**Growth, Environment
& Transport**

12 September 2024

Re: Application for an Order Granting Development Consent for Stonestreet Green Solar – Relevant Representation Submission

Evolution Power Holdings Ltd
Email: info@stonestreetgreensolar.co.uk
www.stonestreetgreensolar.co.uk
©Evolution Power Ltd.

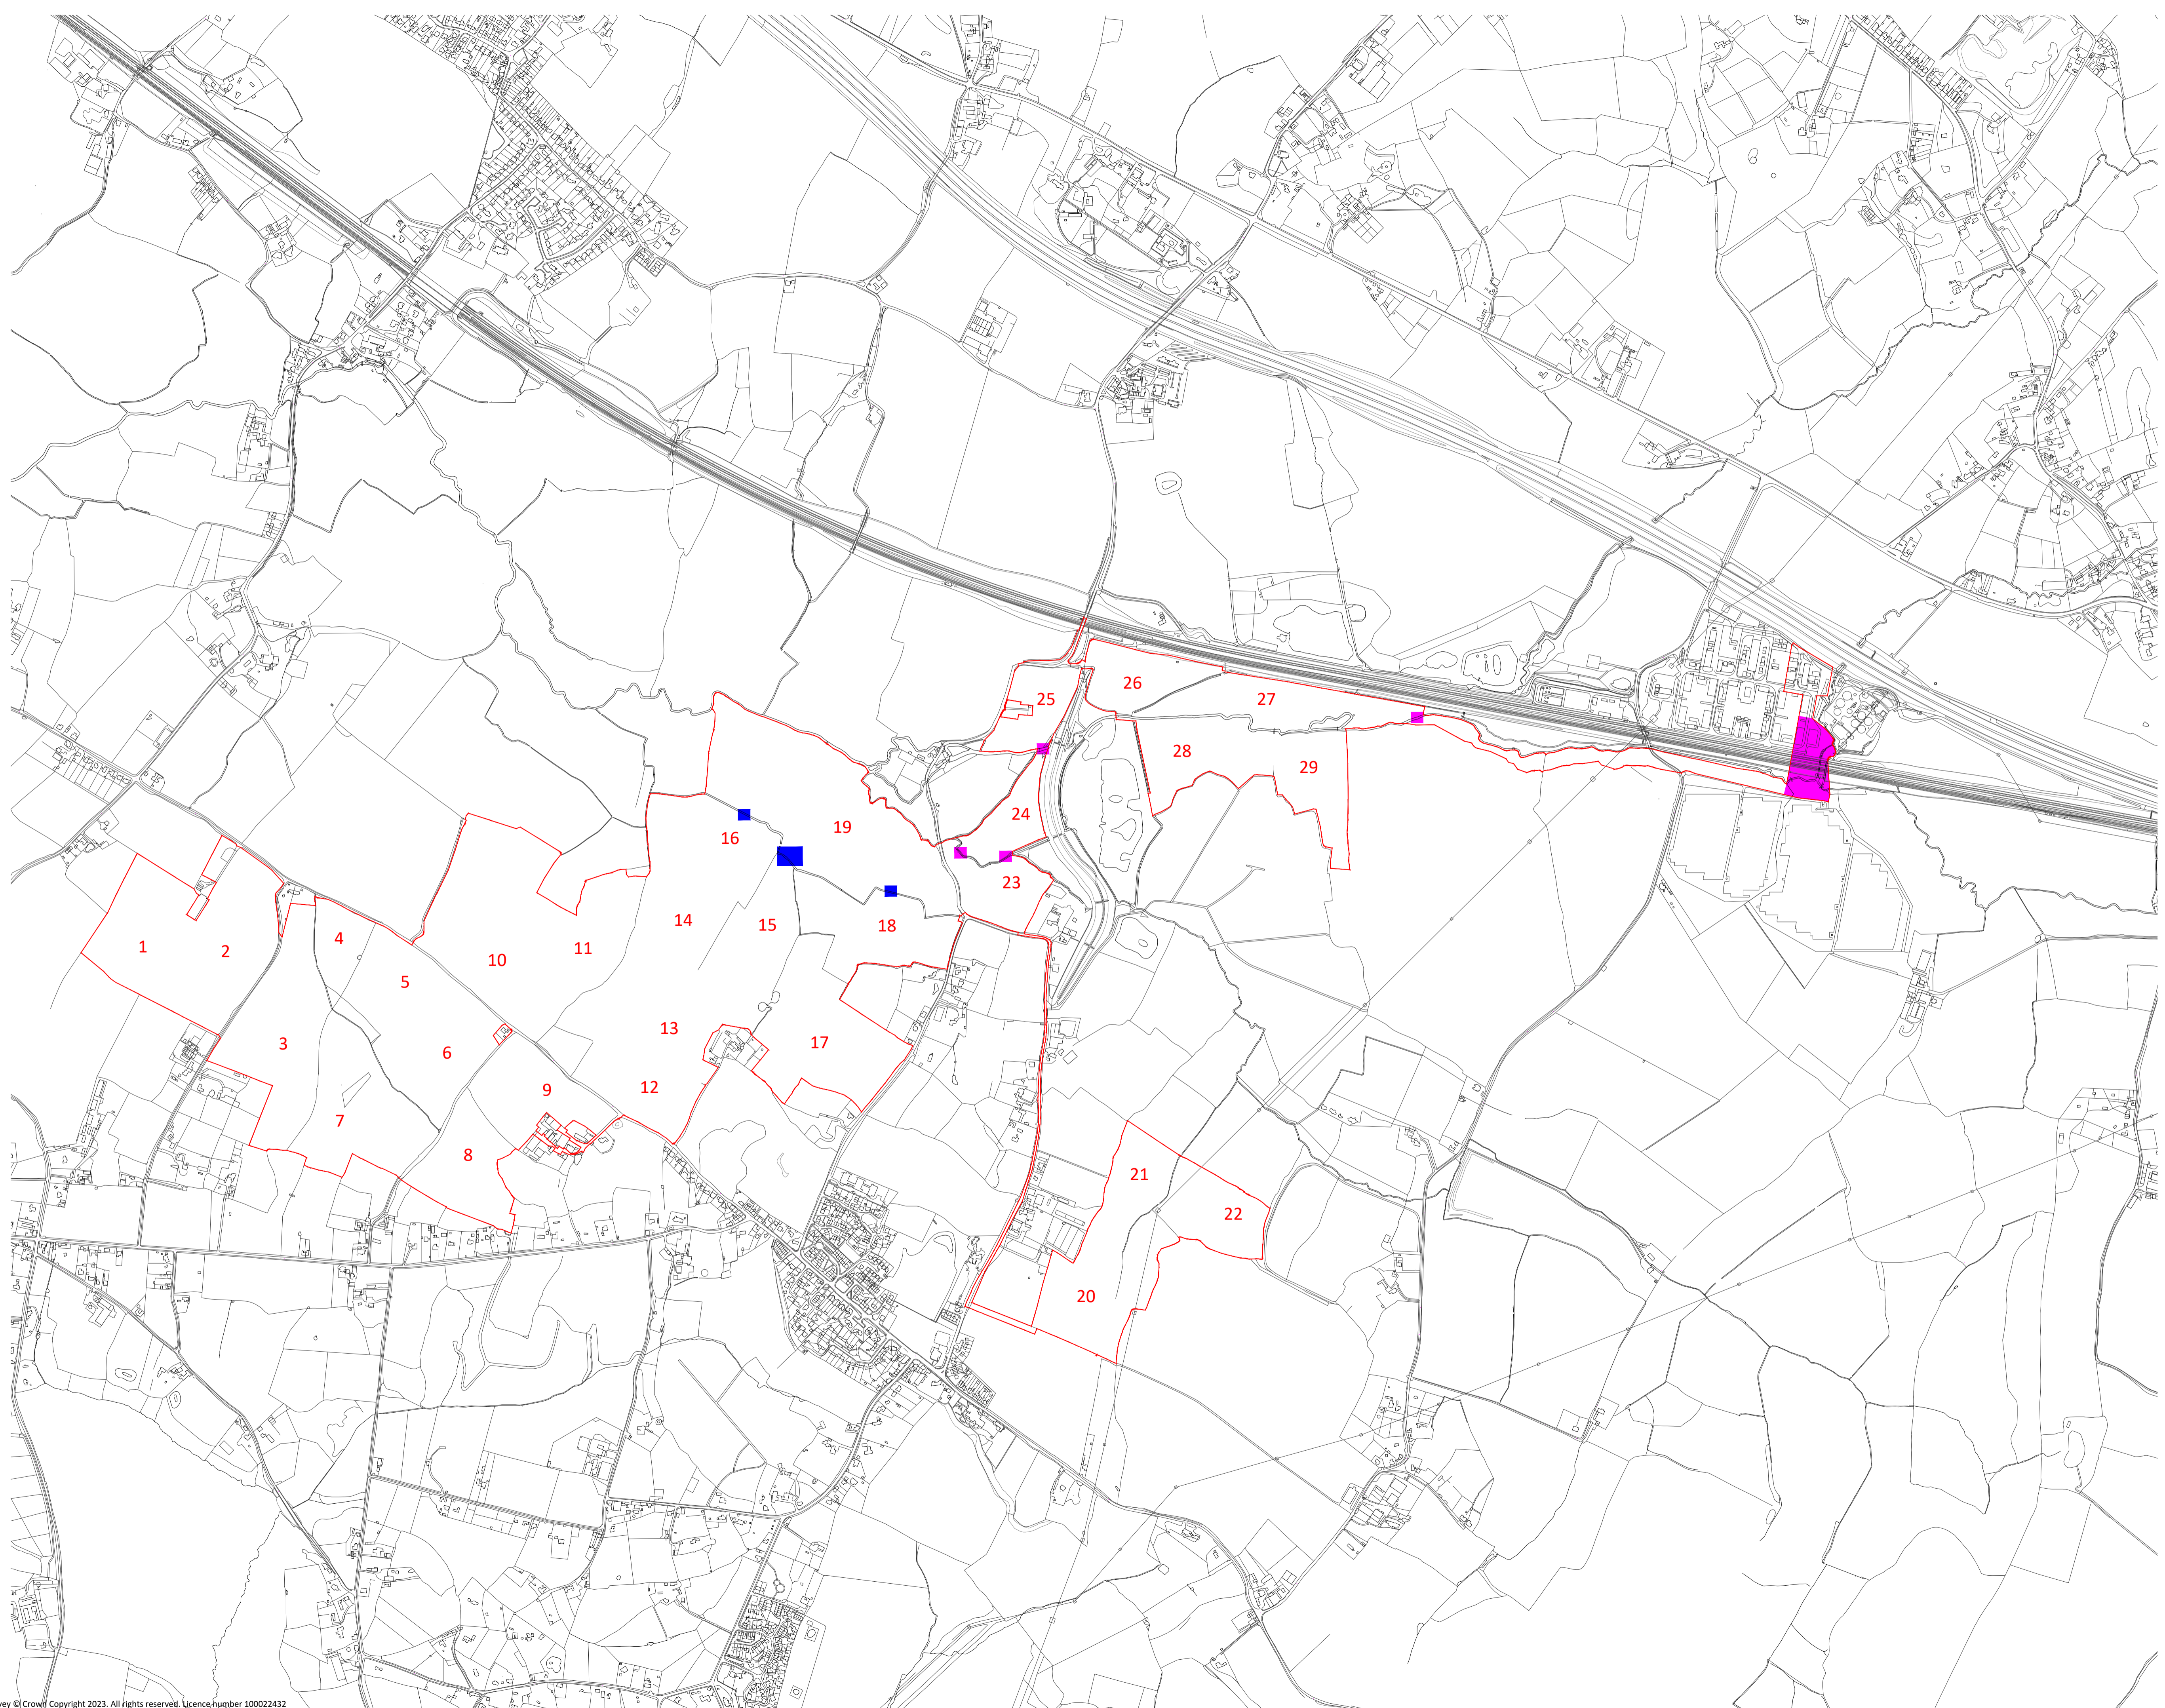
As part of the access strategy, to reach all of the plots to the south of Bank Road, the proposed routing as shown uses the existing access road to Bank Farm. Although the crossing of Bank Road itself can be undertaken via traffic management, the Bank Farm access road is already restricted in width and only wide enough for one-way working for vehicles. Visibility is not adequate from the southern end of the access road to the Bank Road junction to prevent conflicting movements. Any resulting reversing manoeuvres of large vehicles for both direct solar site traffic or other access users would not be welcomed. There are other business interests and access needs on Bank Farm and increased use of this access road with large vehicles with no improvements would not be sensible. Localised widening to the access road to allow for overtaking space, taking account of forward visibility, should be implemented. Revision/clarification on this issue is required by the County Council ahead of the commencement of the Examination.
